Subject: RE: Saltbox Unit 9 site Planning Condition 12 response Surface water

Paul Cann
Principal Drainage Engineer
Engineering Services

2. Specify gully lateral gradients/outlet & inlet levels. ie. those that connect to manholes S1 and S3. Laterals to be 150mm diameter laid at 1/150 to keep connection levels as high as possible. Gully lateral gradients and inlet levels shown – unable to lay at 1 in 150 to raise S1 due to very minimal cover which would potentially cause hard spots within the car park construction where cover is less than the asphalt construction depth. Now ok

PROJECT ORIGINATOR ZONE LEVEL TYPE ROLE NO	Revision
114378-CAL-XX-XX-DR-D-0201	C

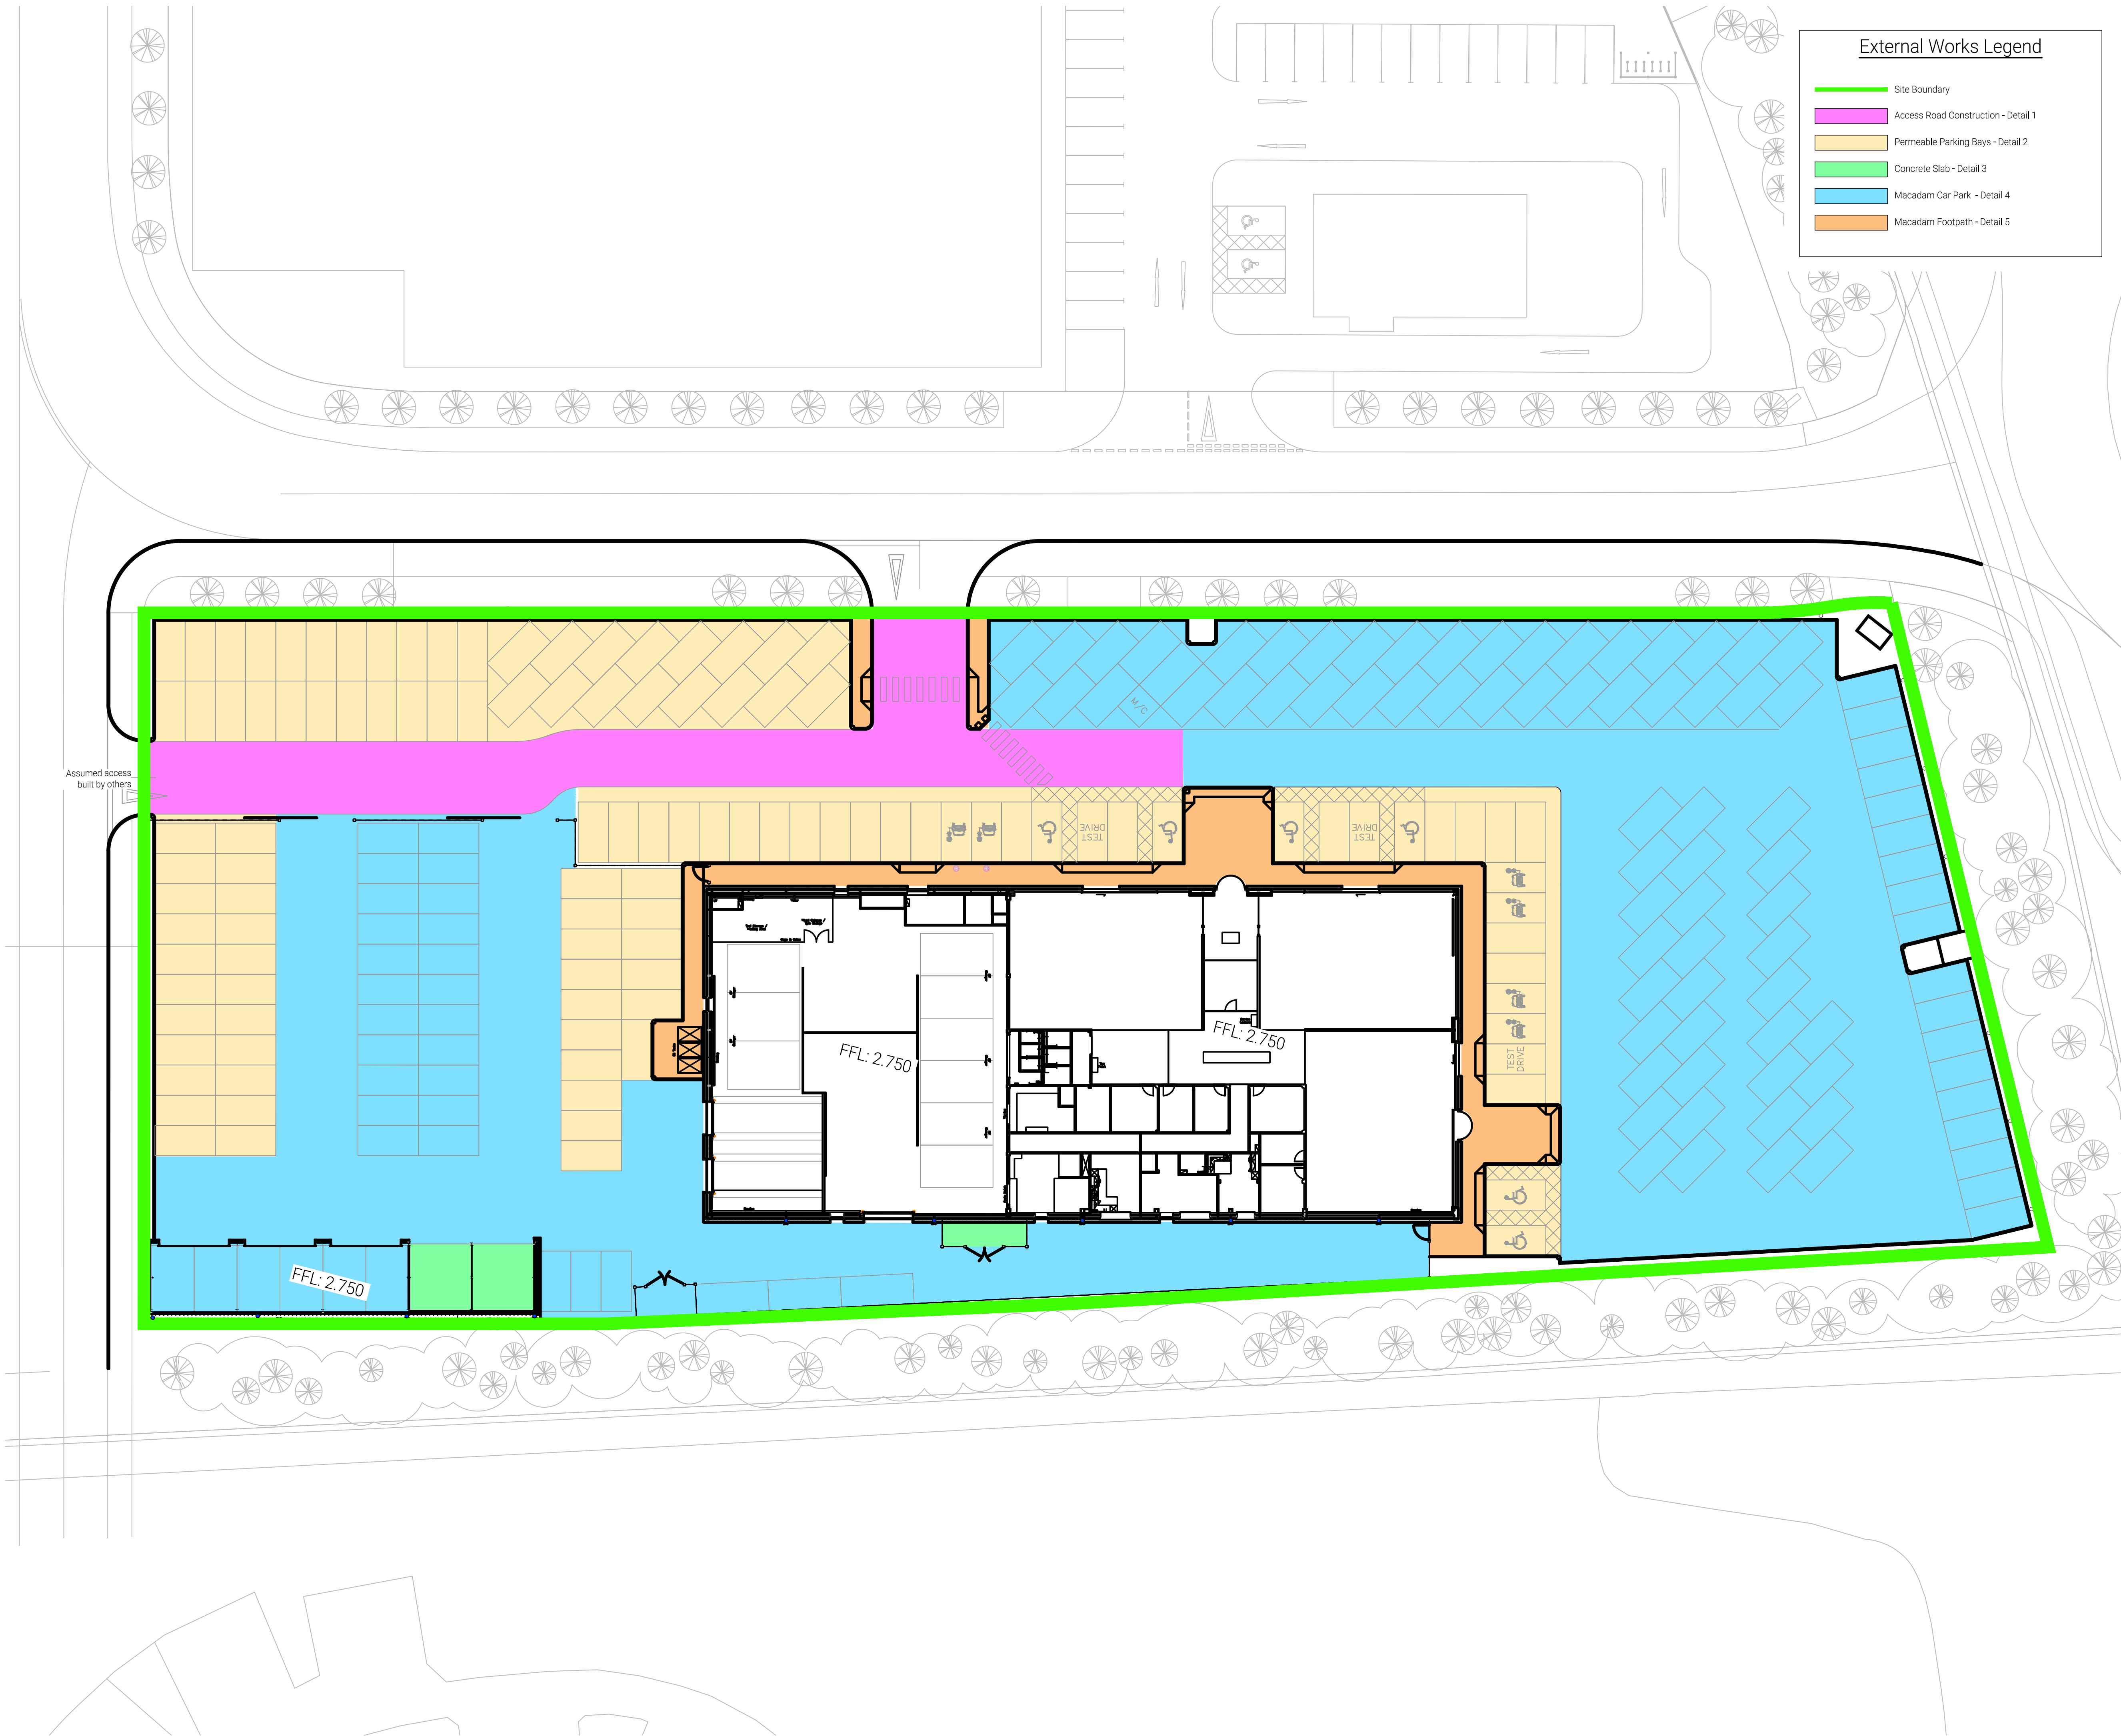
3. Manhole S3 – error in invert level on layout plan ie. 1.722/1.772. Invert level at S3 corrected to 1.722. ok
4. Manhole S8 is missing connections on manhole level schedule. Connections to S8 added to schedule as requested. ok

6. Pipeline 1.002 – correct gradient to allow for bypass separator levels. Adjust levels of separator ie. outlet is lower than invert of manhole S11 downstream. Levels of the bypass separator amended. ok

7. Specify all inlet invert levels to attenuation tank. Invert levels to all attenuation tank inlets shown. Include connection at S22 and 375mm pipe inlet levels. Slacken gradients on pipelines 8.000 to 8.003 to avoid an invert to invert connection into the tank. ie. lay 150mm at 1/150, 225mm at 1/225, 300mm at 1/300, if possible.

11. Manhole S7 – two incoming connections with no obvious purpose? This is a small section of perforated pipe within a narrow gravel margin around the building line. It is anticipated that barely any flow will enter these pipes. Ok but please adjust note on plan to refer to manhole S7 as opposed to S2.

15. Road gullies in southwest corner – specify diameters and gradients and ensure all connect to chambers on the attenuation tank. These are rainwater pipes from the vehicle washdown area. I have added diameters and gradients to the plan as requested. Ok but slacken all RWP + channel outlet gradients (ie. 1/100) so connections into the tank are as high as possible.

16. Gully connection into manhole S22 – reconfigure to improve angle of connection into manhole. We have added a 45-degree bend for straight connection into the attenuation tank. Layout plan not amended + Tubosider plan to be adjusted.

P.C.C. Ring Catchpit Manhole Detail

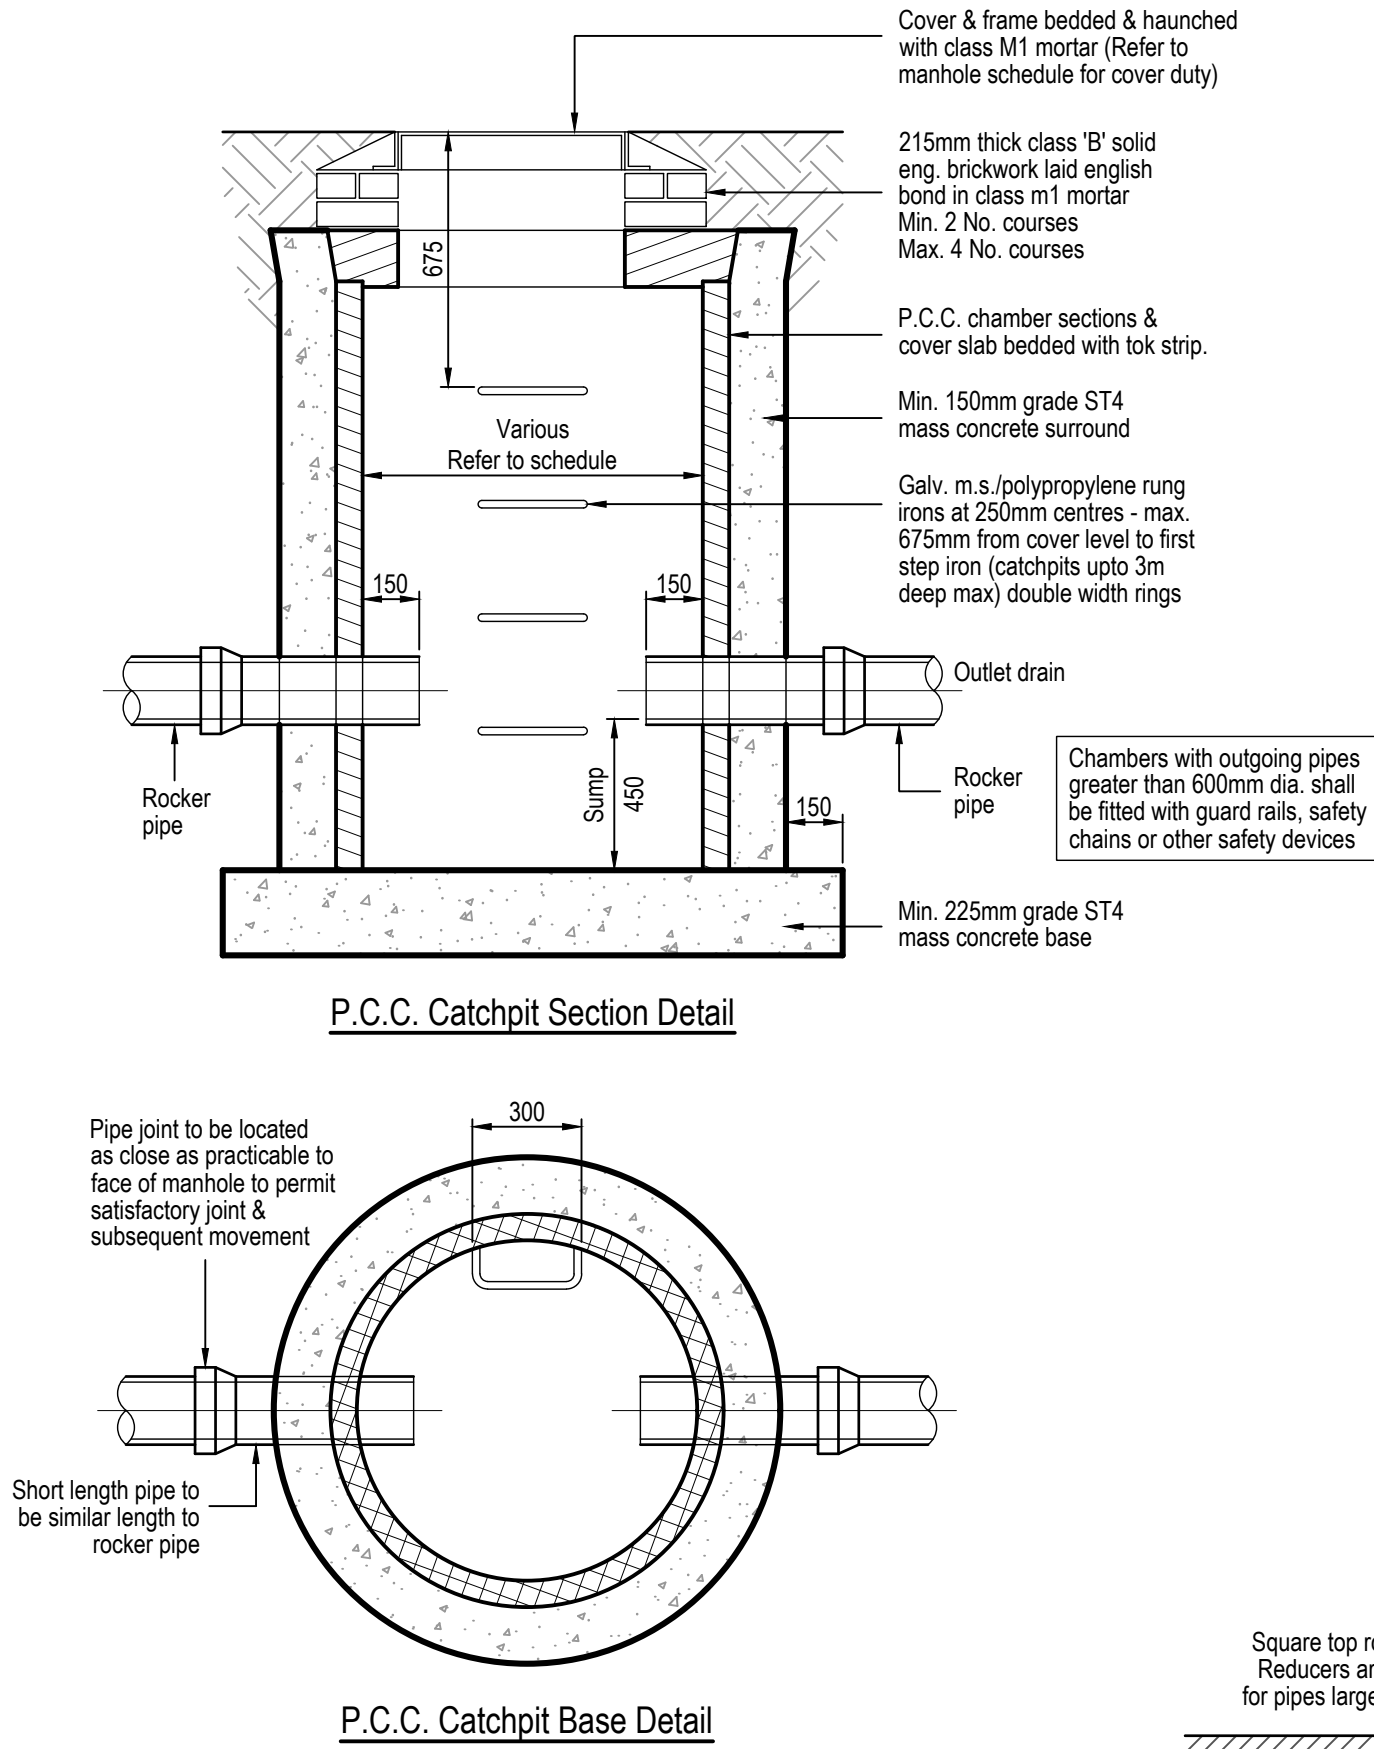
32. PCC ring catchpits; Specify min; 450mm sump.
33. Permeable paving/collection pipe detail – formation level geomembrane to be permeable as opposed impermeable to make use of any possible infiltration, no matter how minimal.

31. Provide construction detail for rodding eyes. Rodding eye construction detail added to dwg 0502 attached. ok
32. PCC ring catchpits; Specify min; 450mm sump. Sump increased to 450mm minimum as requested. ok

Road Gully Detail (P.C.C.) Adjacent Kerb (With Smart Sponge Filter)

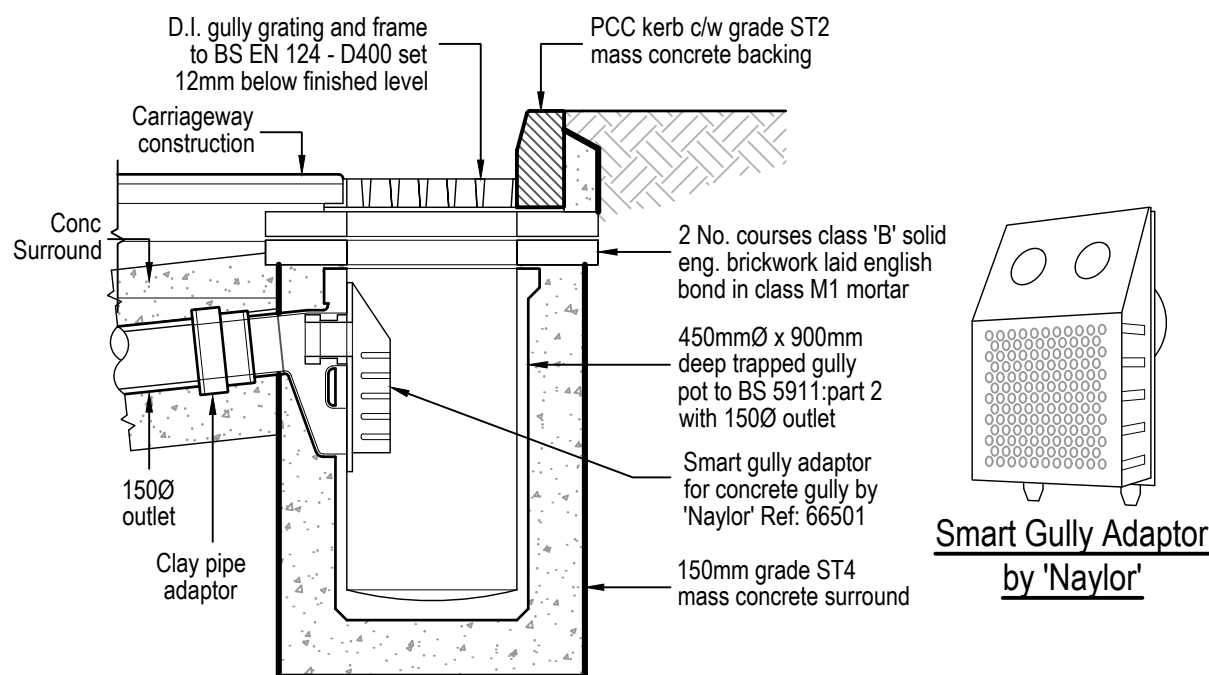
26. Provide fully detailed road gully construction details including pipe diameter.
27. Provide hydrobrake technical details data sheet from the manufacturer.

26. Provide fully detailed road gully construction details including pipe diameter. Construction detail dwg 0502 attached with gully detail. ok
27. Provide hydrobrake technical details data sheet from the manufacturer. Hydrobrake technical details attached. ok

Perm Paving/Gravel Margin Perforated Pipe Detail

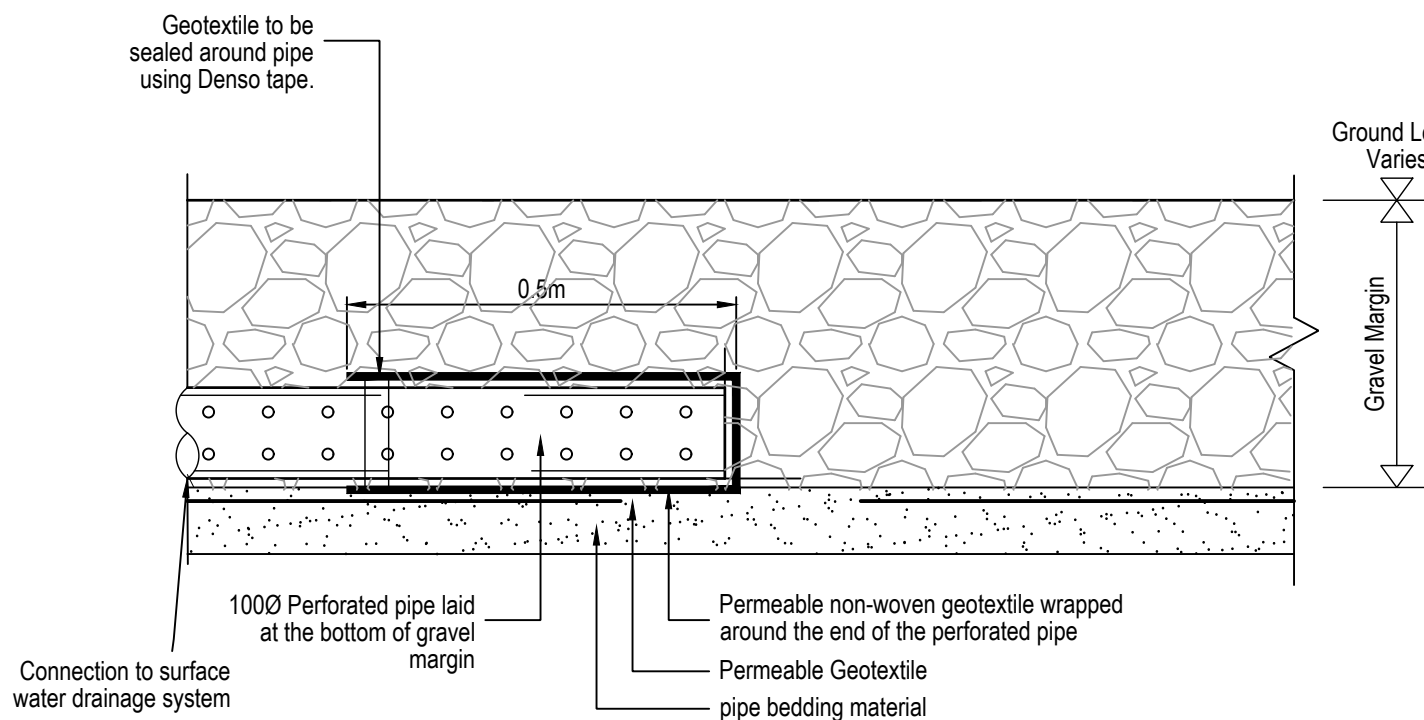
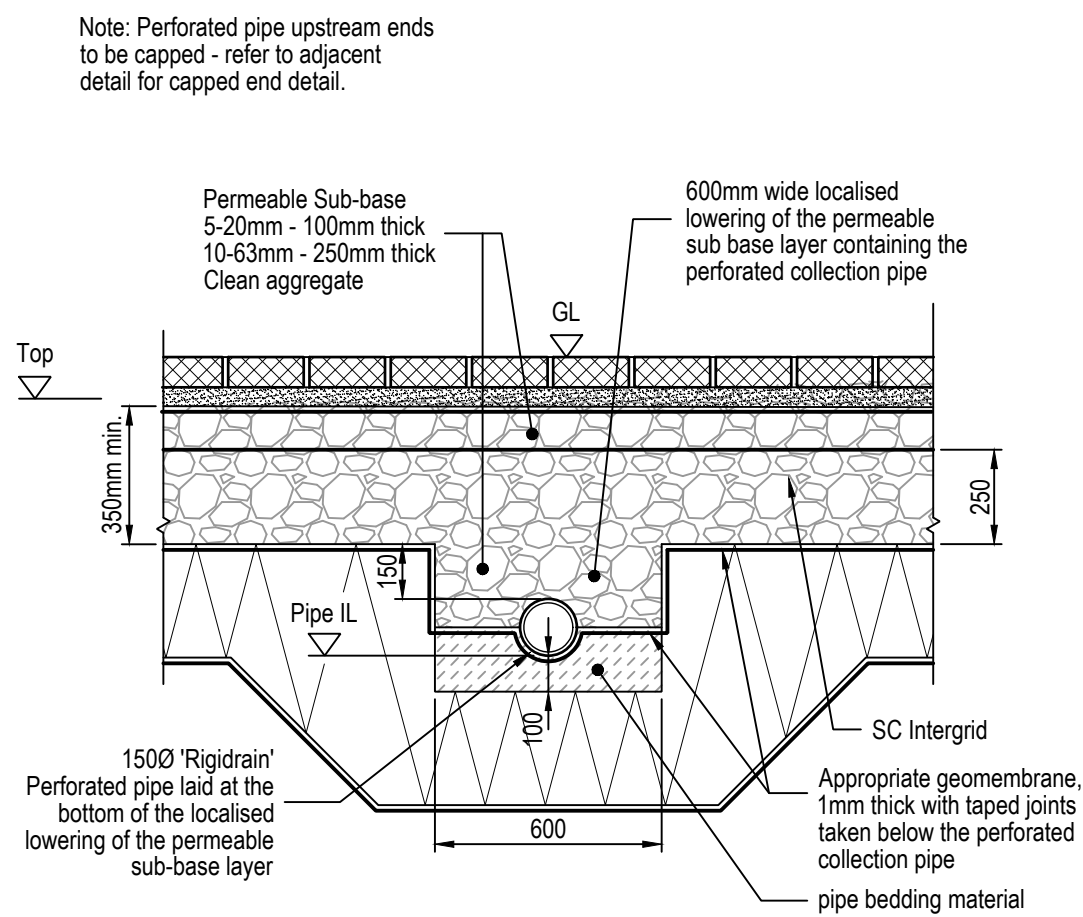
33. Permeable paving/collection pipe detail – formation level geomembrane to be permeable as opposed impermeable to make use of any possible infiltration, no matter how minimal. As per Pauls previous comments, we would have concerns regarding the entry of groundwater into the surface water drainage system. Our design does not have the spare capacity to accommodate any potential groundwater entry. I certainly wouldn't want groundwater entering the system either. On previous phases, permeable paving

formation levels were set above peak recorded groundwater levels. Please confirm the recorded groundwater levels at these locations so it can be discussed further.
